# CITY OF ALBUQUERQUE

**Re: SW Positioning, Inc., 609 Osuna Rd NE  
Engineer's Stamp dated 10-11-2012 (E16/D031)**

GRADING & DRAINAGE PLAN

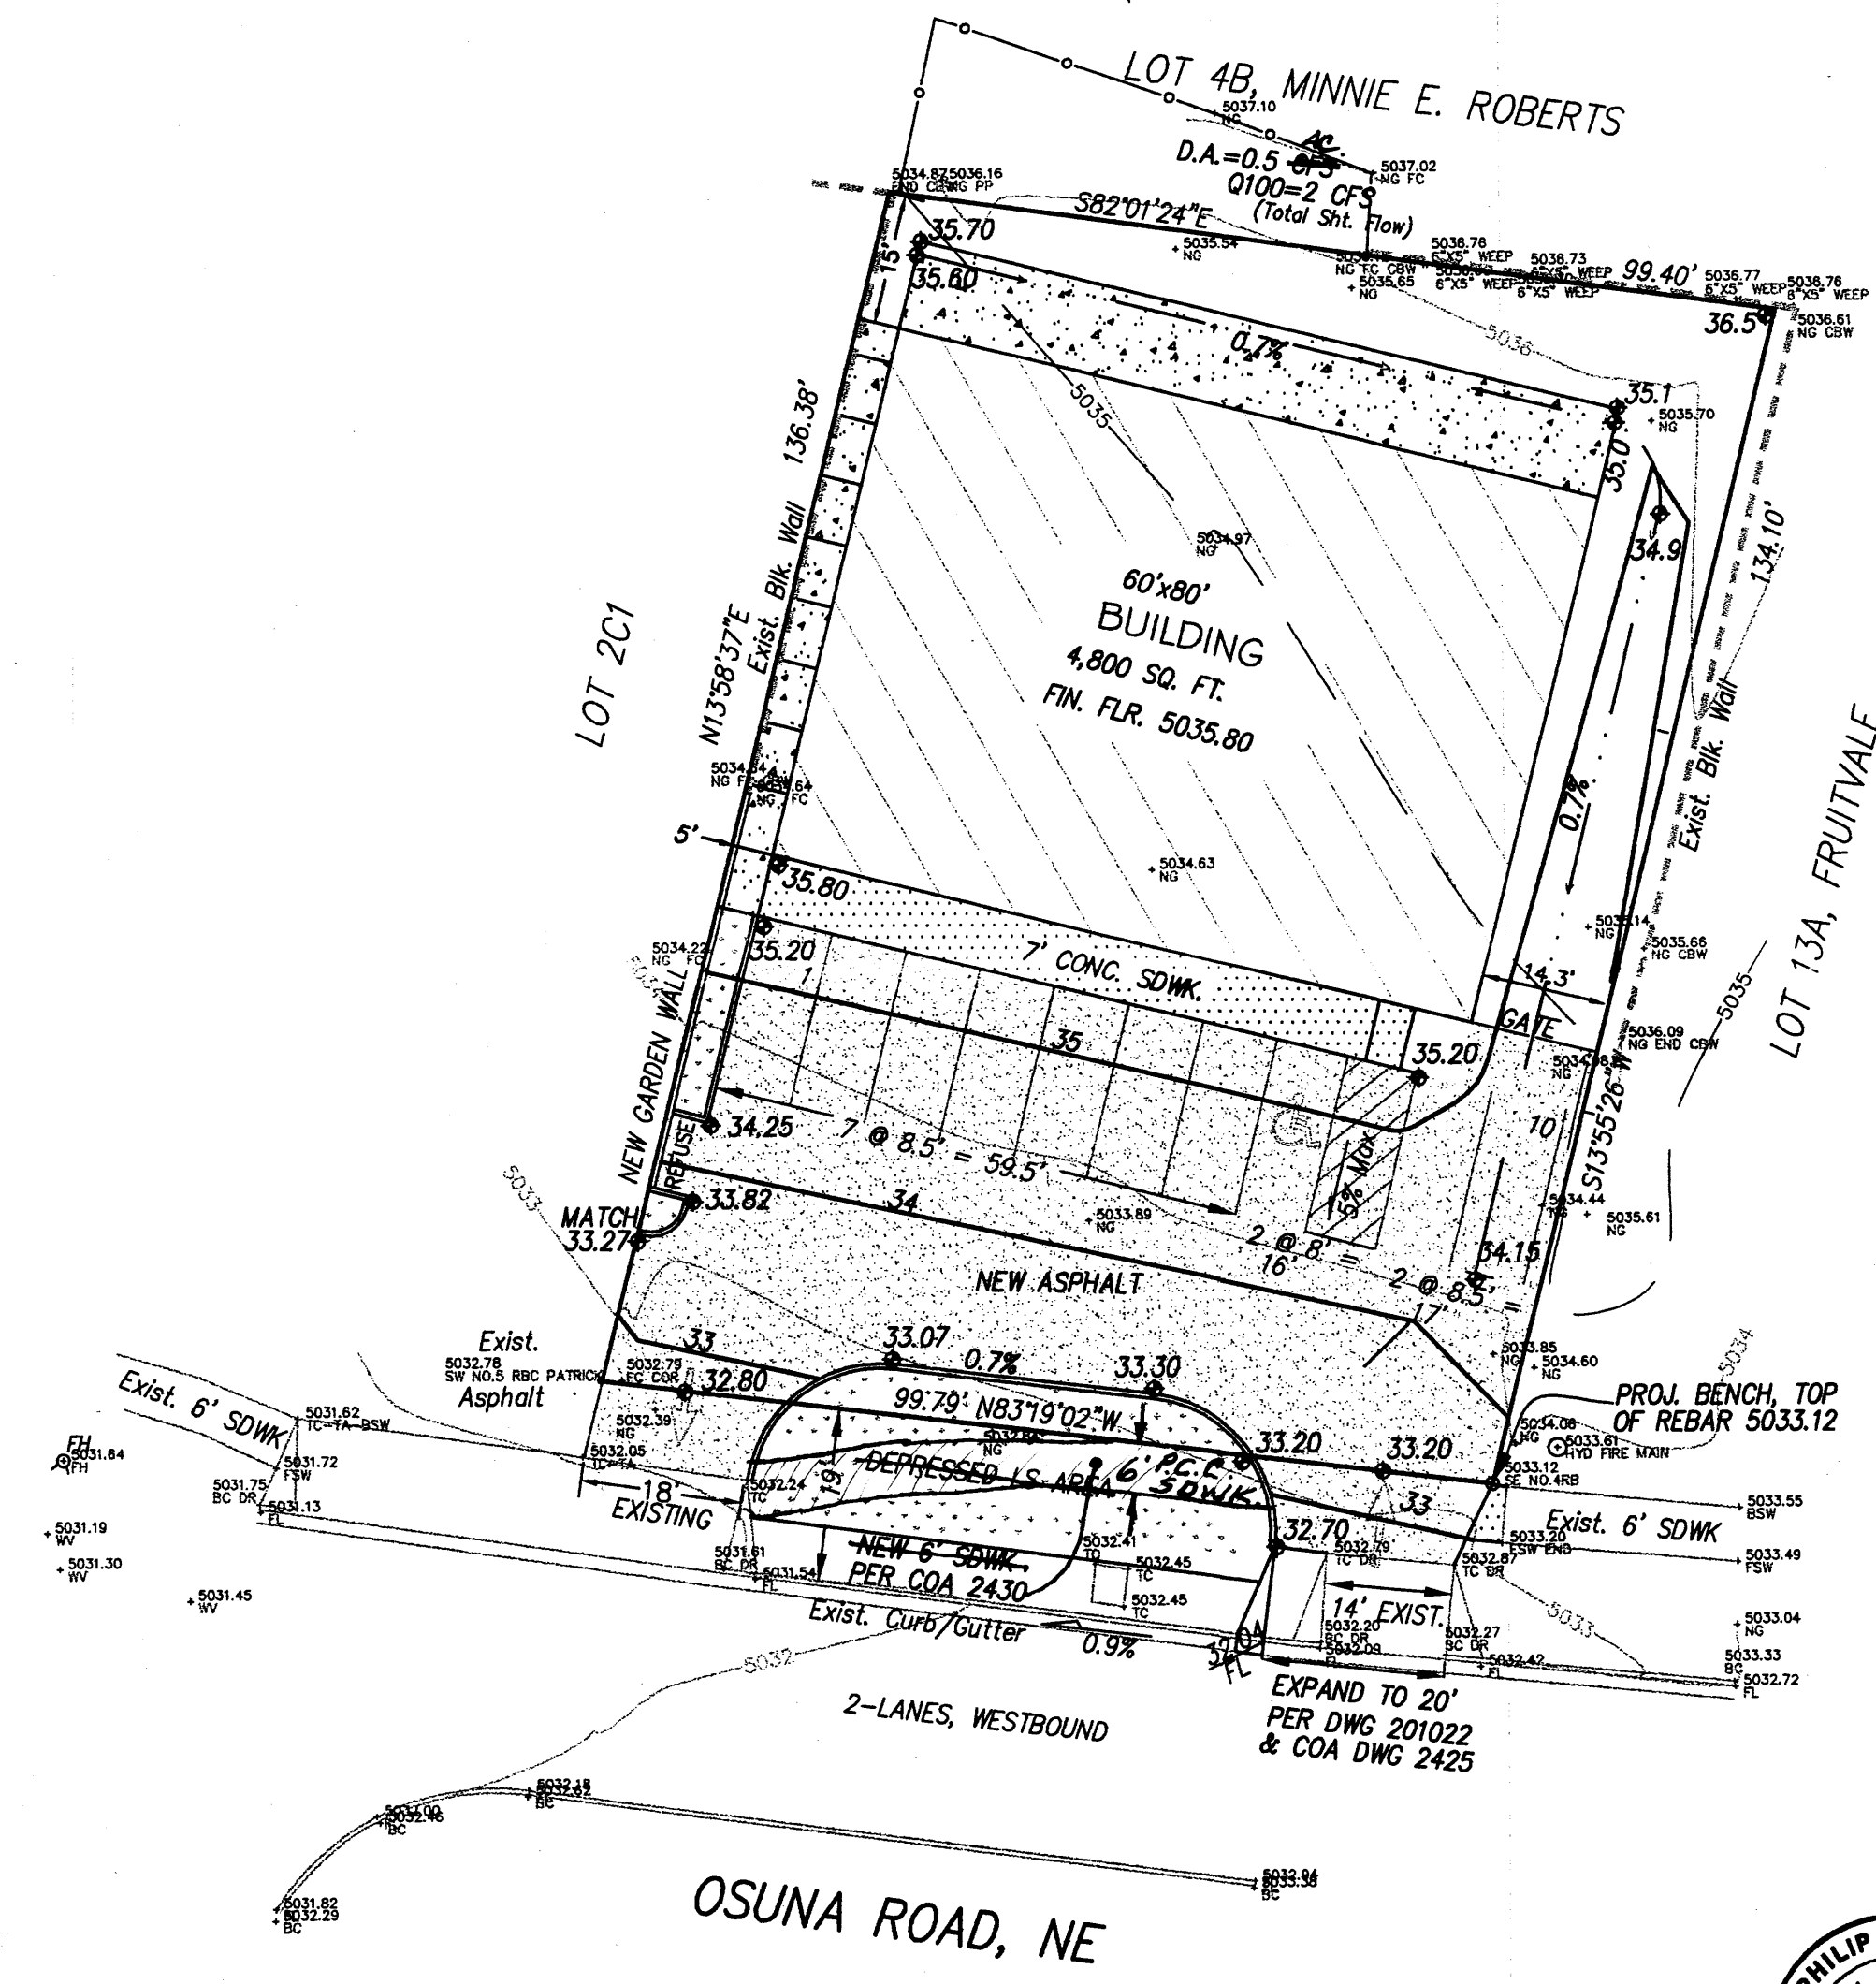
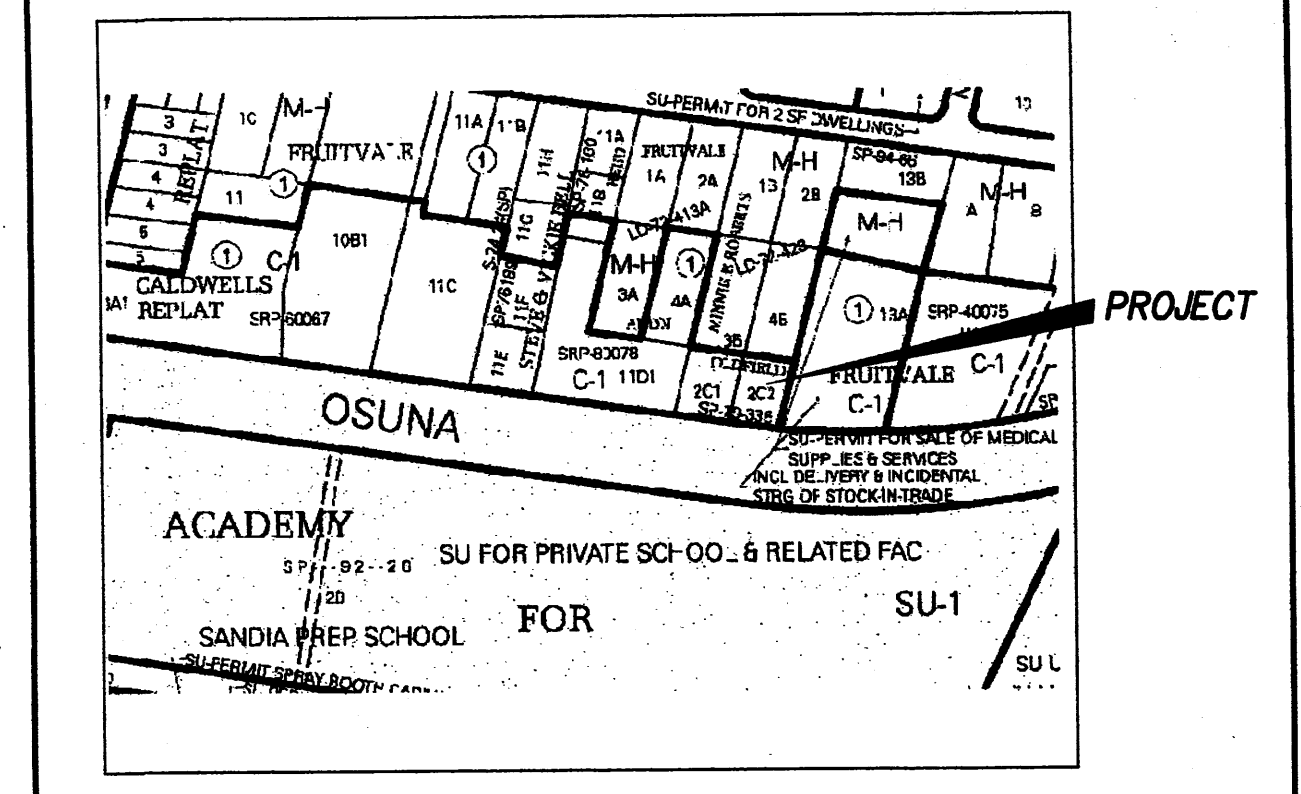
The grading and drainage plan was submitted on 10-15-2012. Sidewalk was modified, and the depressed landscaping area within the ROW was removed and marked on the original plan on 10/26/2012 by Mr. Clark. Based on these modifications on the original, the Plan is approved for the proposed discharge into Osuna ROW.
